From: Paul Cann <Paul.Cann@arun.gov.uk>
Sent: 24 February 2022 10:29
To: Planning.Responses <Planning.Responses@arun.gov.uk>
Cc: Roger Spencer <Roger.Spencer@arun.gov.uk>; Sarah Burrow <Sarah.Burrow@arun.gov.uk>;
laura.gibbons [REDACTED] Michael Eastham <Michael.Eastham@arun.gov.uk>; Claire Potts
<Claire.Potts@arun.gov.uk>
Subject: RE: Planning Consultation on: BE/4/22/DOC

Engineers comments in respect to 'Surface Water Drainage' Condition 12:

Application No: BE/4/22/DOC
Registered: 18th January 2022
Site Address: Unit 9 Salt Box Field Land off Rowan Way Bersted PO22 9NW
Description of Works: Approval of details reserved by condition imposed under hybrid application BE/135/18/PL relating to Full Condition Nos 3 - materials & finishes, 4 external lighting, 10 - hard & soft landscaping, 12 - surface water drainage, 16 - foul drainage, 21 - CCTV, 28 - acoustic fencing, 30 - security fencing and 45 - levels.

Drainage Layout
Sheet 1 of 2
- Drawing Status

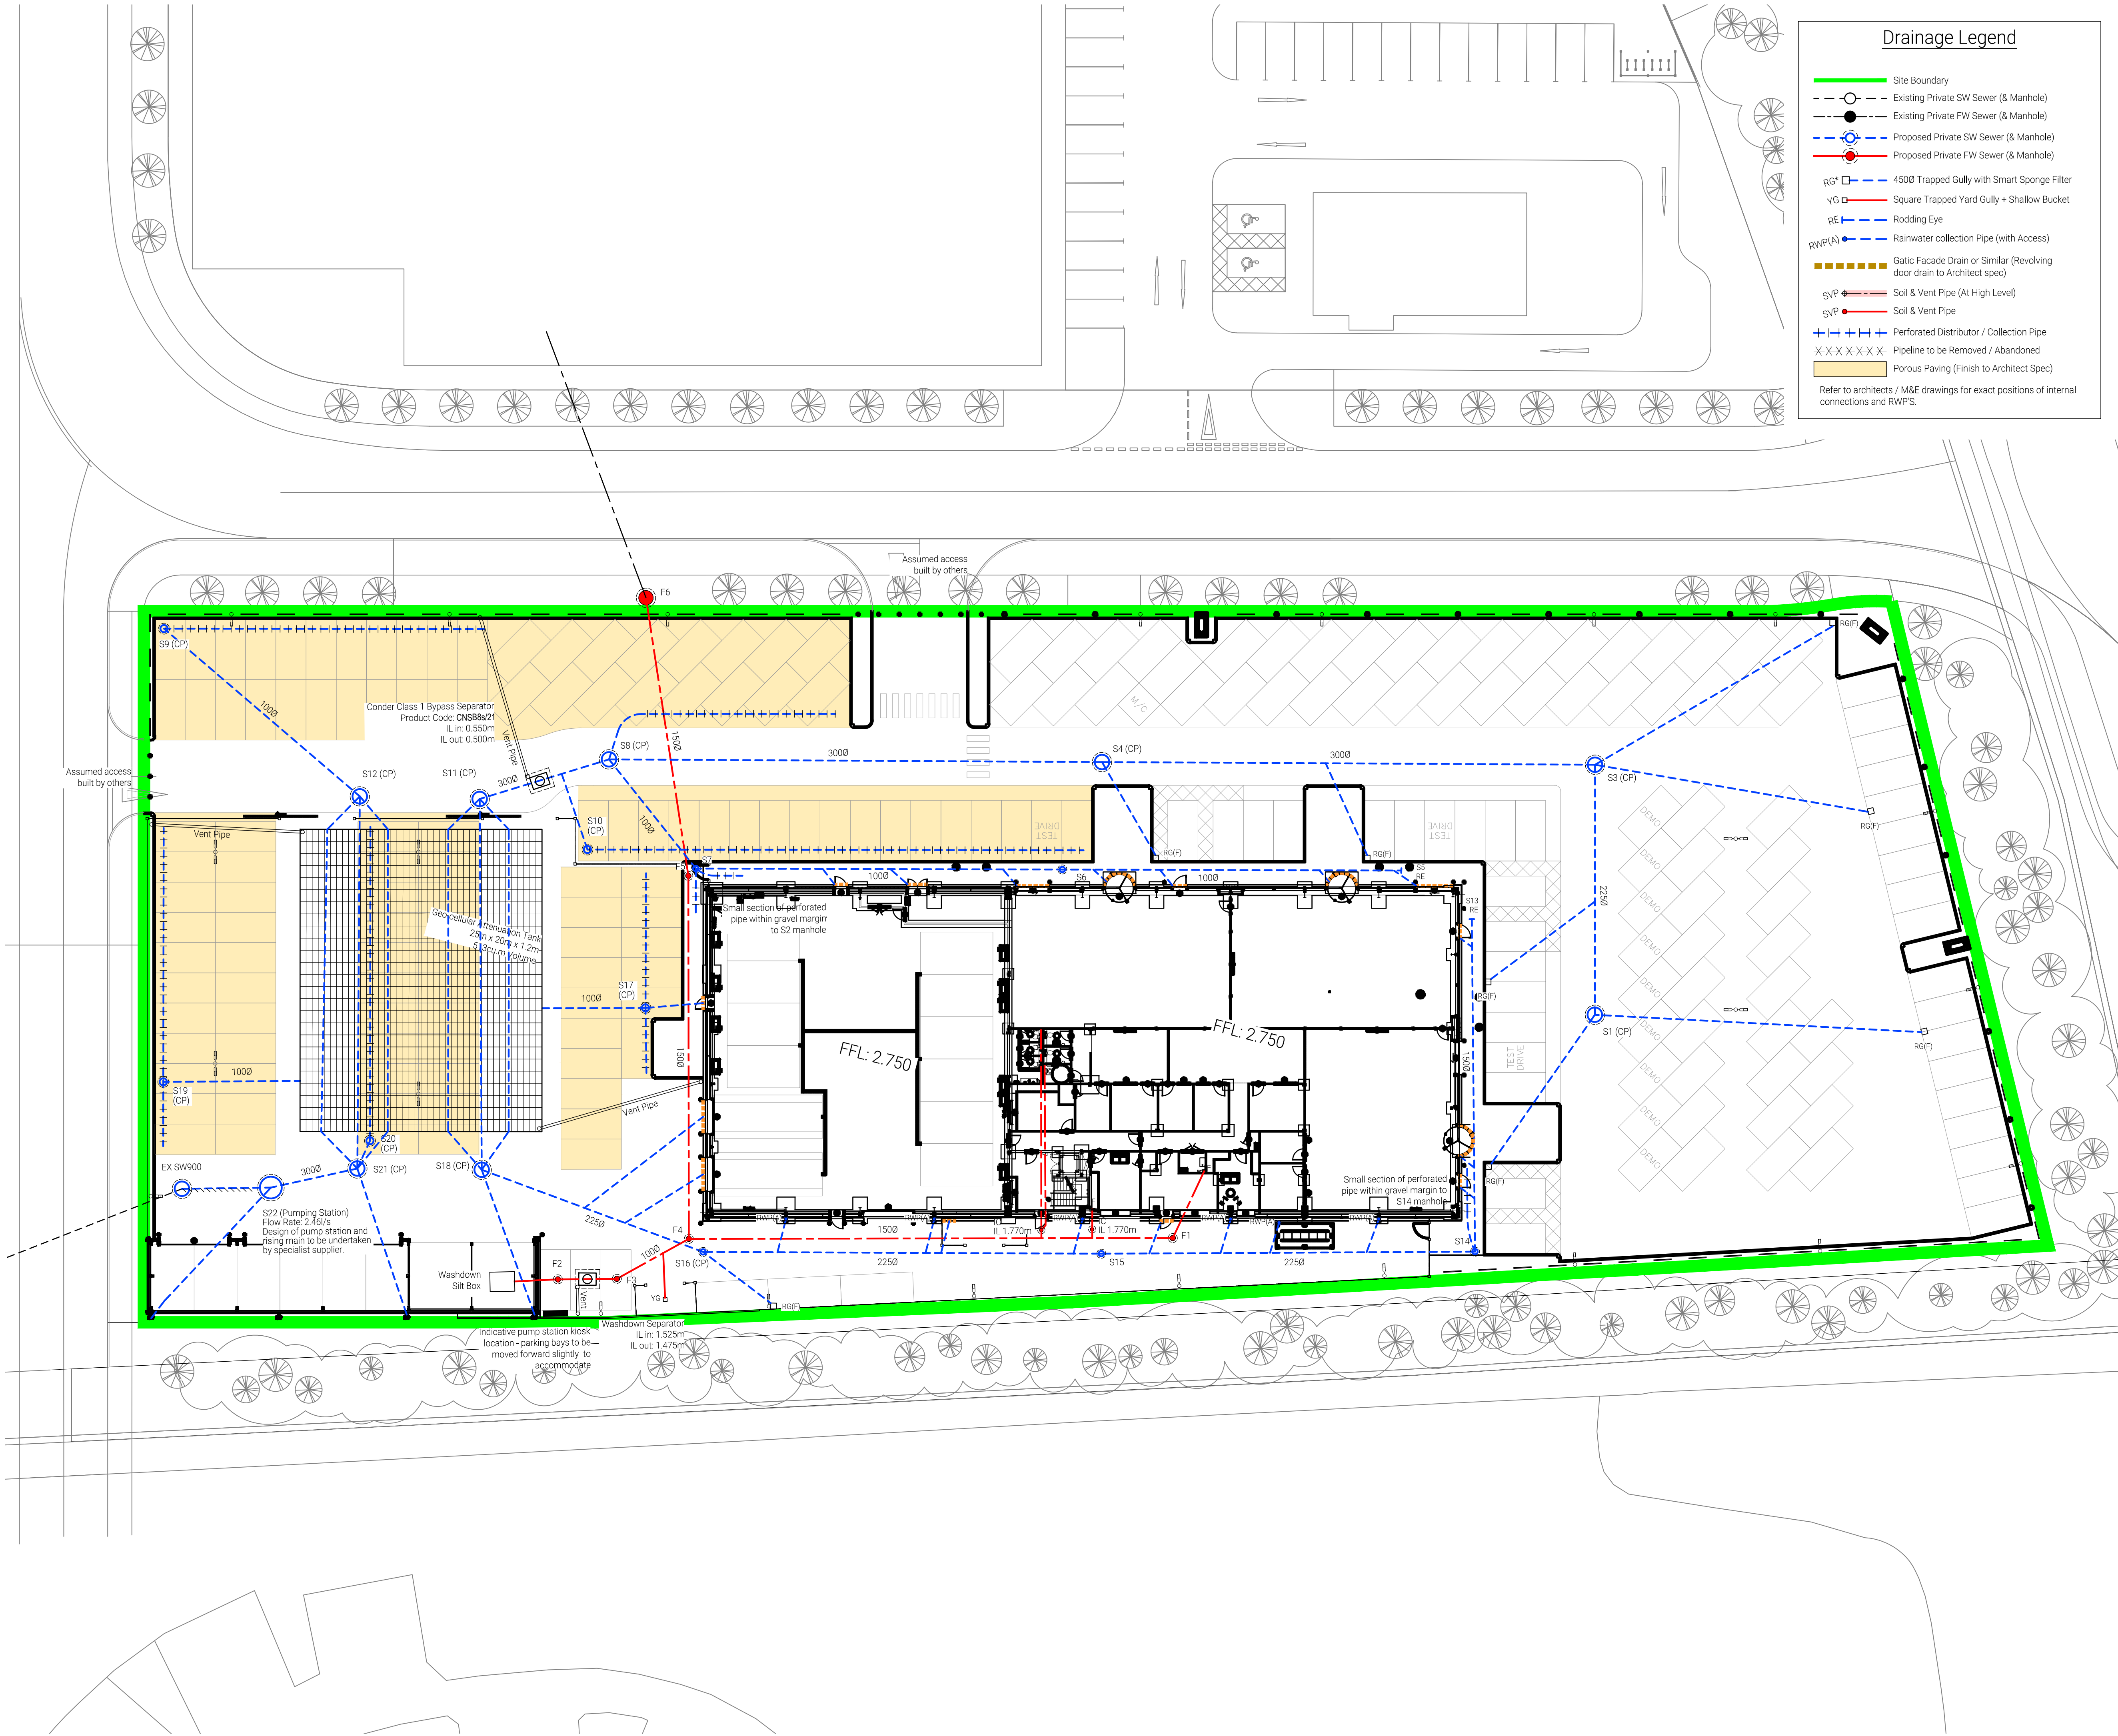
The scheme fails to provide a satisfactory solution ie. a pumping station is being proposed, which is not sustainable and does not align with the envisaged strategy. A gravity solution must be achieved.

Any proposal also needs to be supported by relevant hydraulic calculations to prove that the design storm can be accommodated on site. I confirm that the proposed discharge rate of 2.46 l/s meets the requirements of the 'Hydrock' overall strategy. The applicant should expand the use of permeable paving where possible to improve water treatment, and this could also aid in providing additional shallow storage. For future ease of reference, all cover/invert levels and pipe gradients/diameters need to be included on the layout plan.

Until such time that a revised scheme is presented, I will not be making detailed comments on the proposals. It is therefore recommended that the condition is not discharged at this time.
